Ribble Valley Borough Council

**App no: 25.0867**

**Address: Primrose Mill Business Park Primrose Road Clitheroe**

**Proposal: Proposed demolition of part of an existing building and creation of a new space for delivery vehicles.**

Client Seawood Investments Ltd		
Job Title Proposed Partial Demolition of a Building to Create Space for Delivery Vehicles Primrose Business Park Primrose Road Clitheroe		
Drawing Title Proposed Site and Floor Plan and Elevations		
Scale 1:200/100@A1	Date Oct 2025	Drawn CHS/LKR

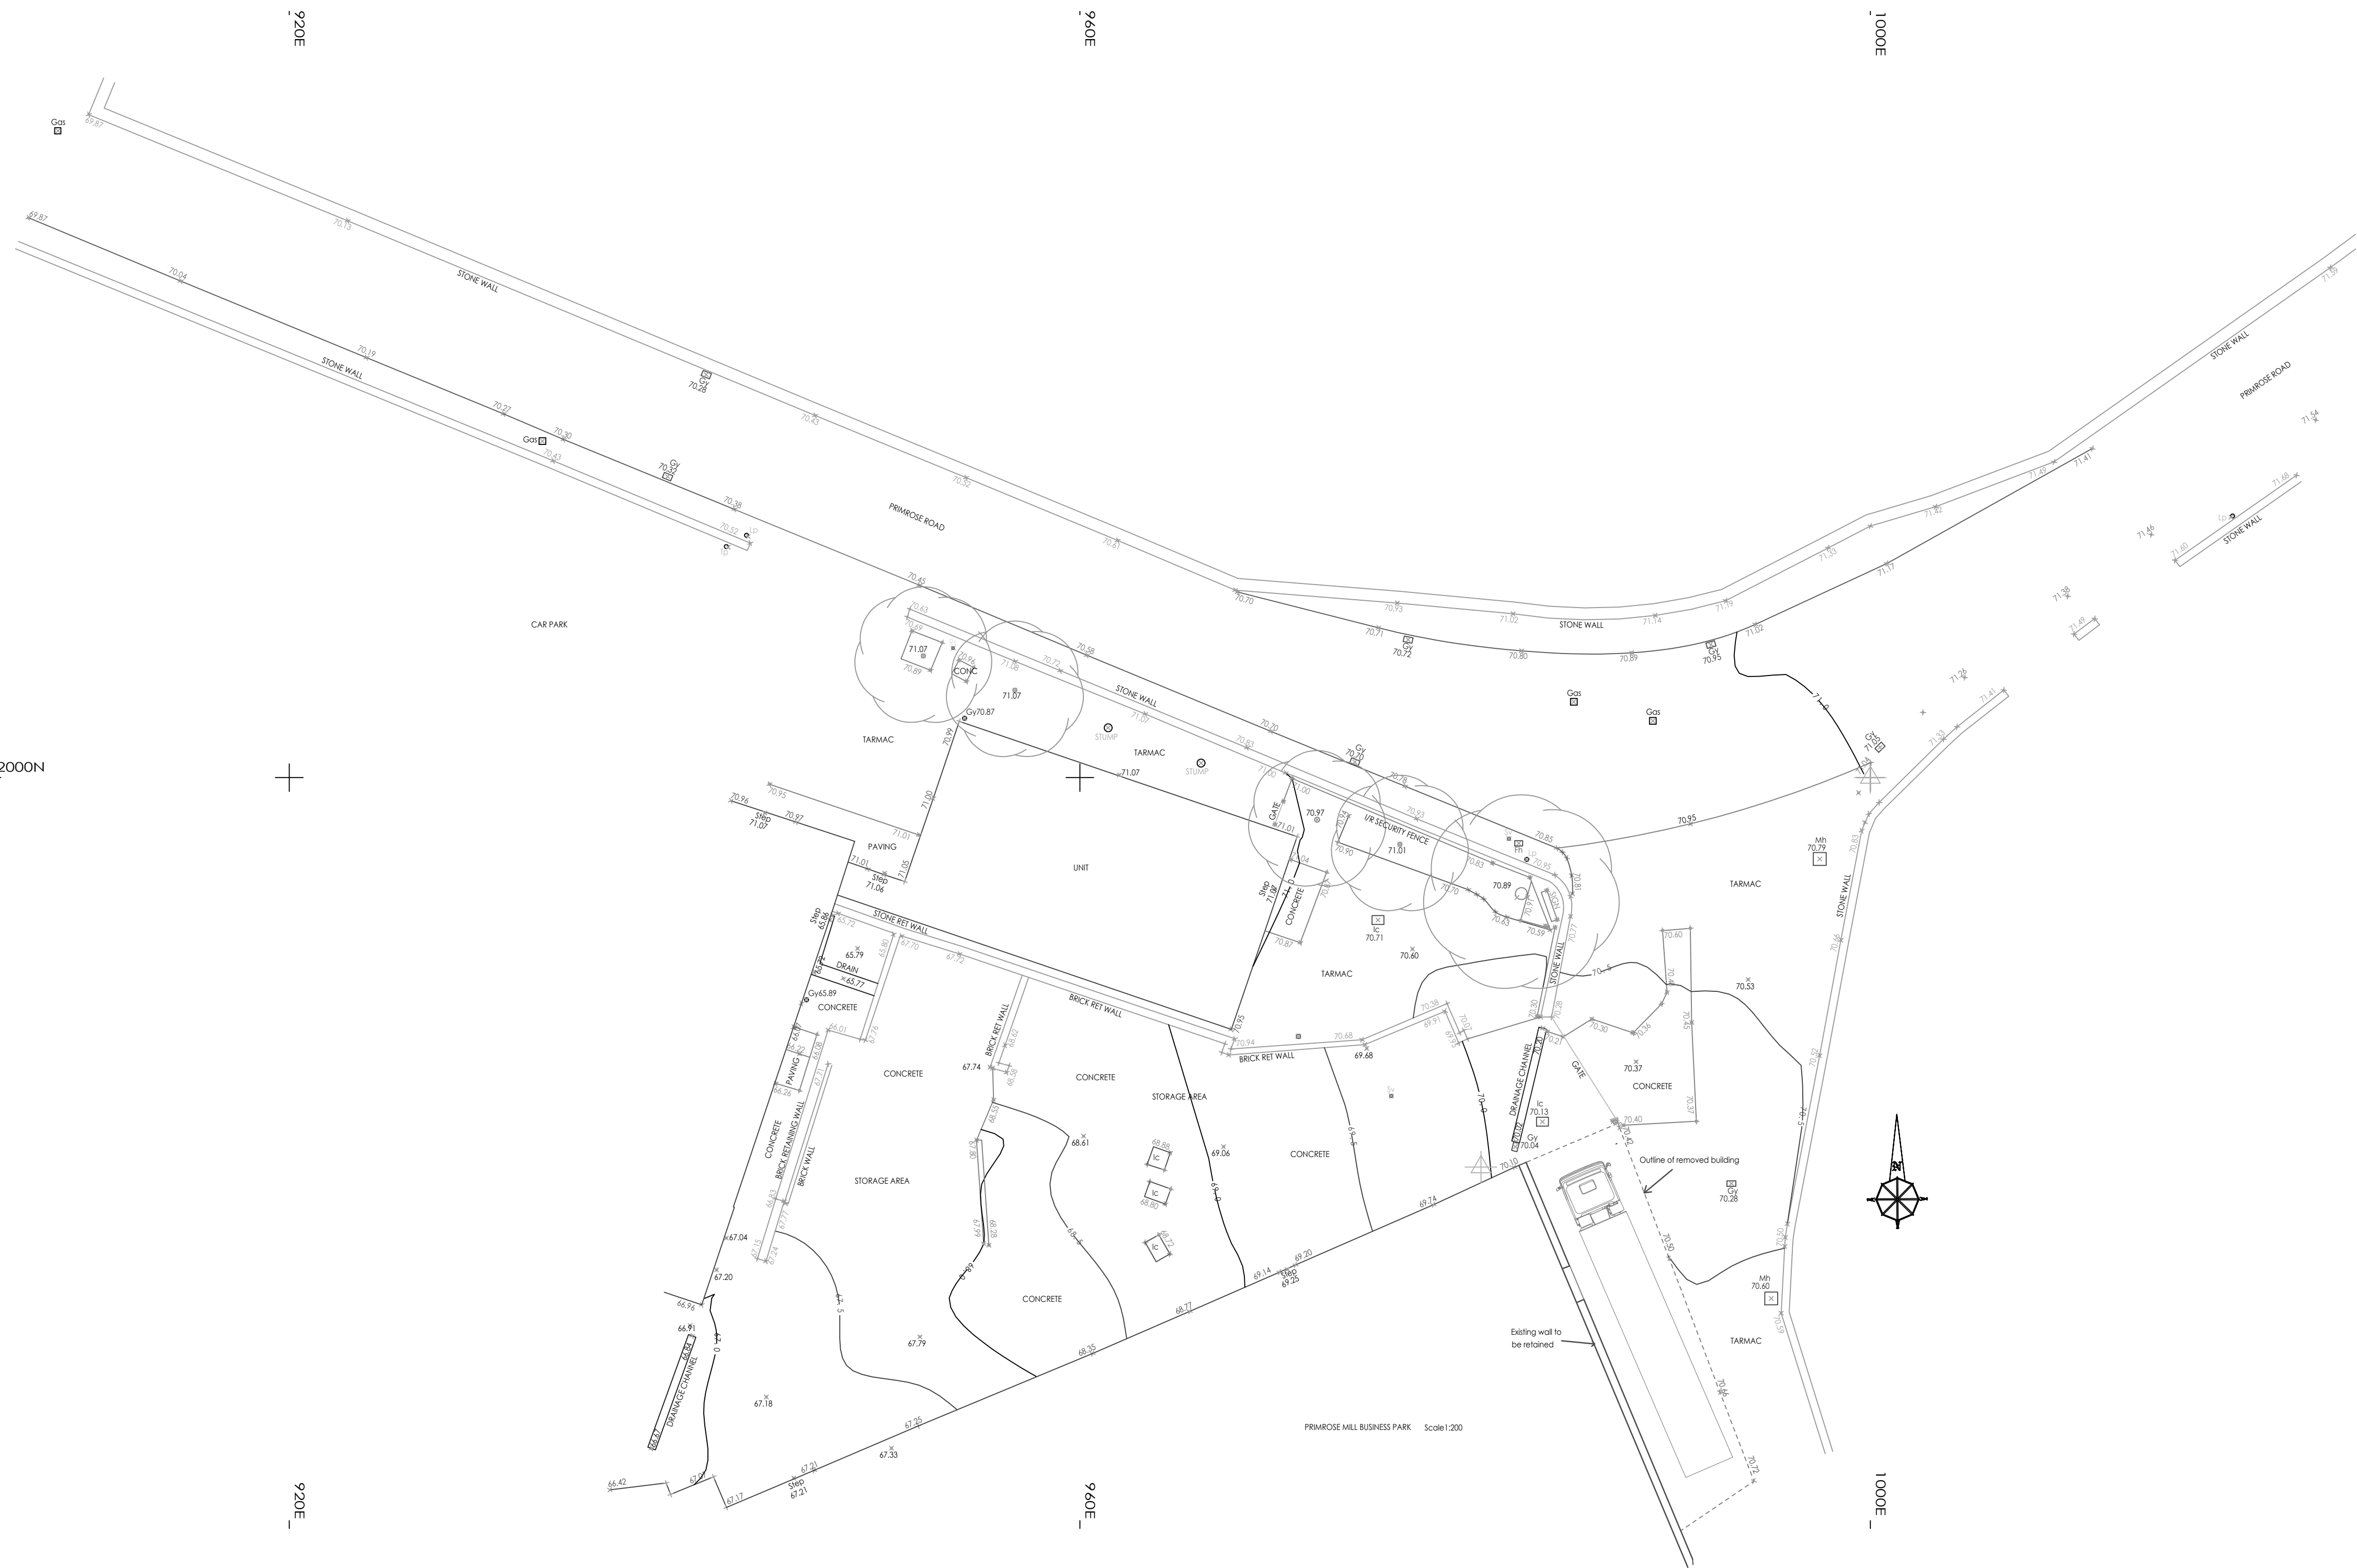
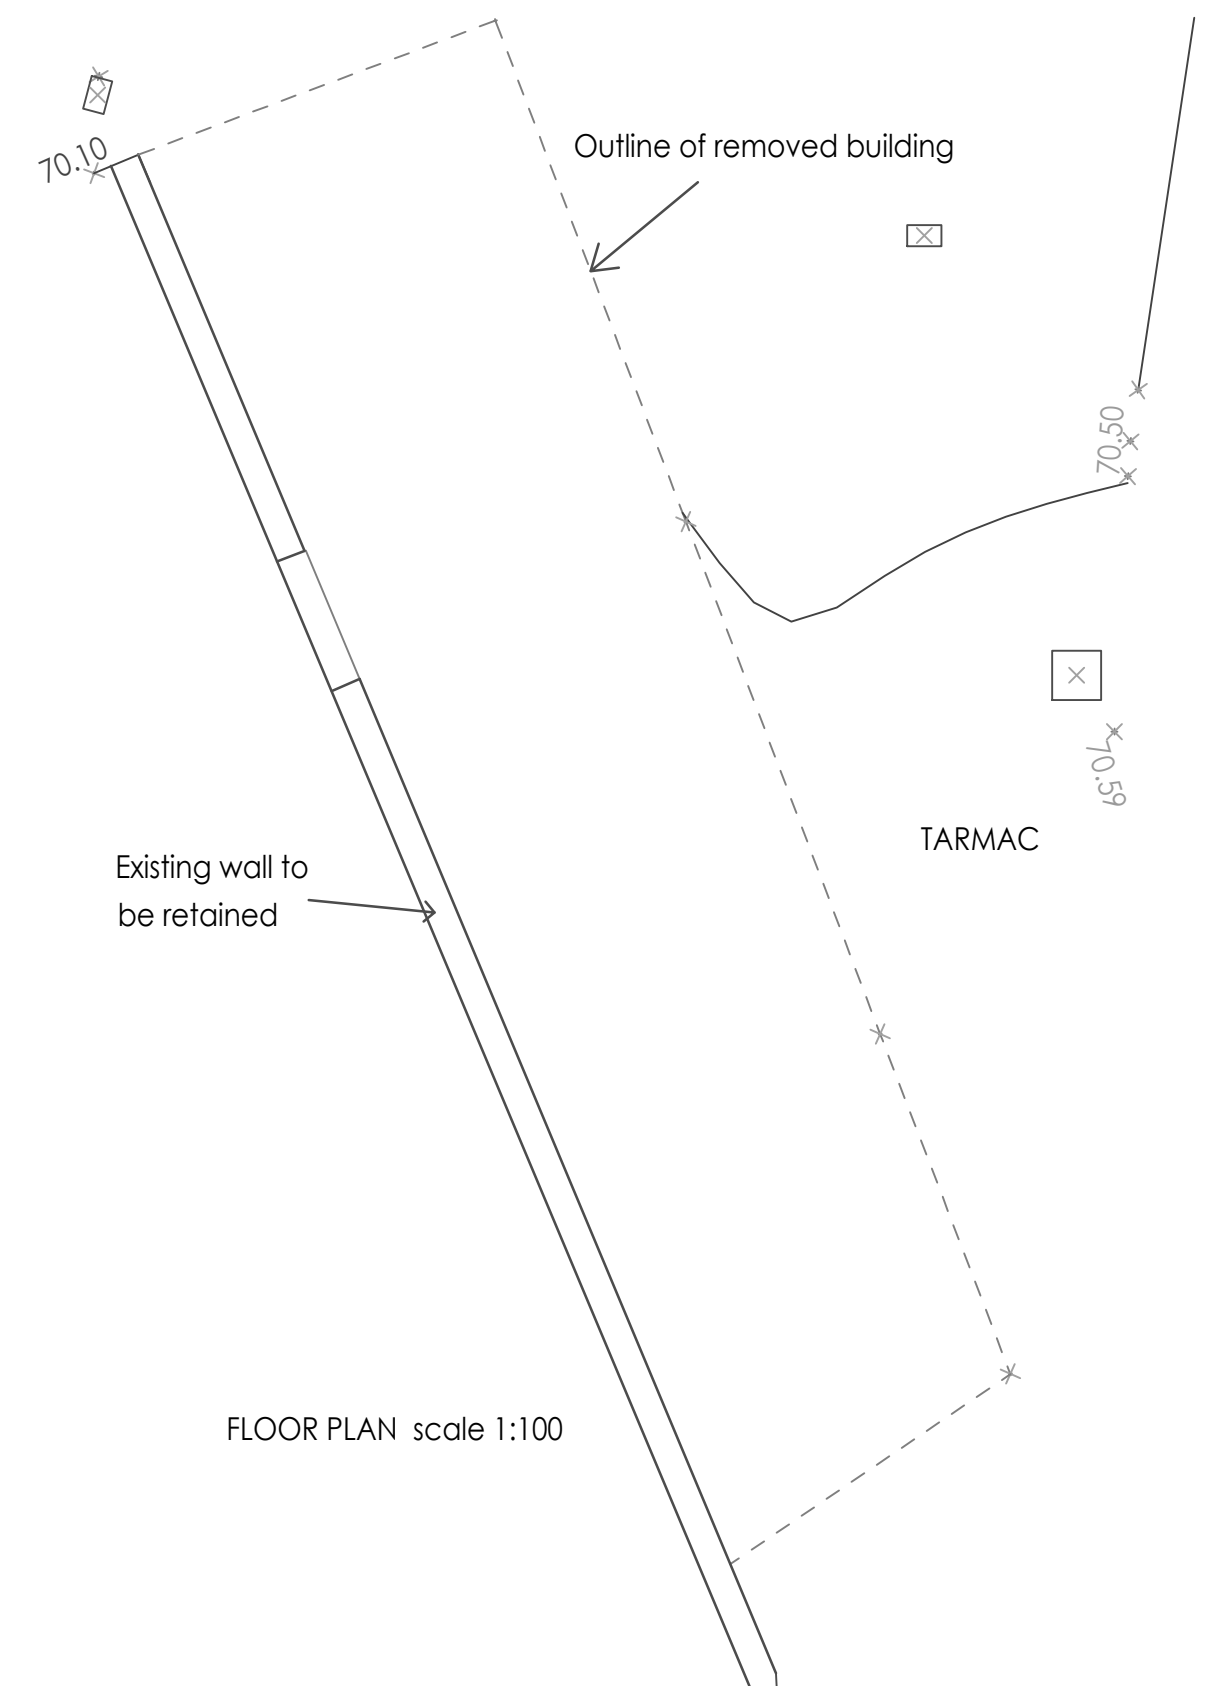
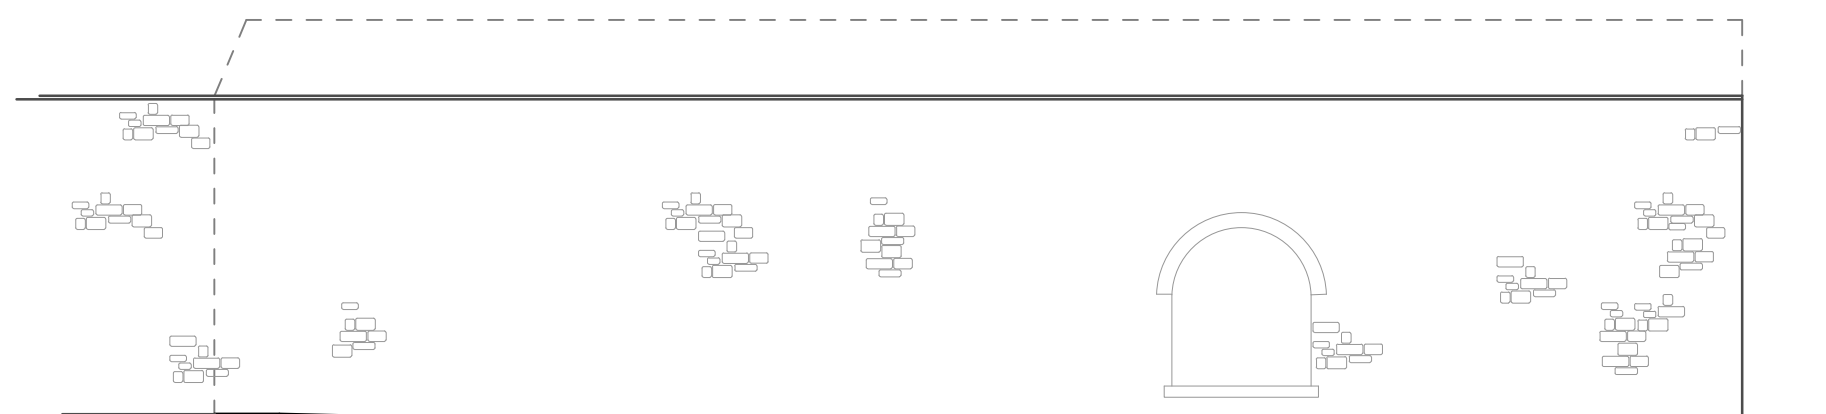
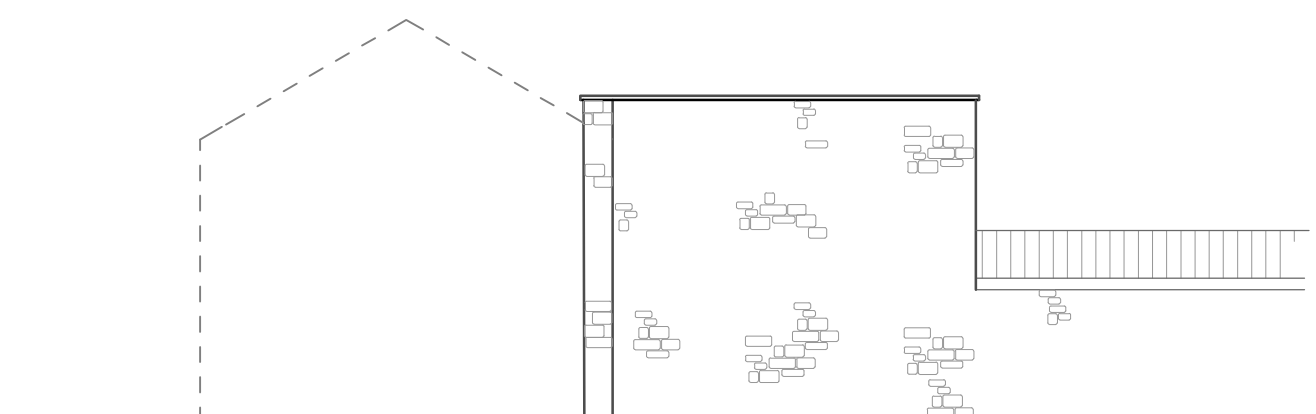
The purpose of the demolition of the building is to use the footprint for the parking of HGV's whilst they are loaded/unloaded, HGV's that would otherwise be parked on Primrose Road.

We would request that the applicant confirms this or otherwise.

There are no surface construction, surface water or boundary treatments submitted for the proposal. Please confirm these.

There is a public footpath FP0332001 running to the east side of the building to be demolished. Users of the public footpath must be protected during the demolition phase and thereafter from any ongoing conflict arising from the use of the access.
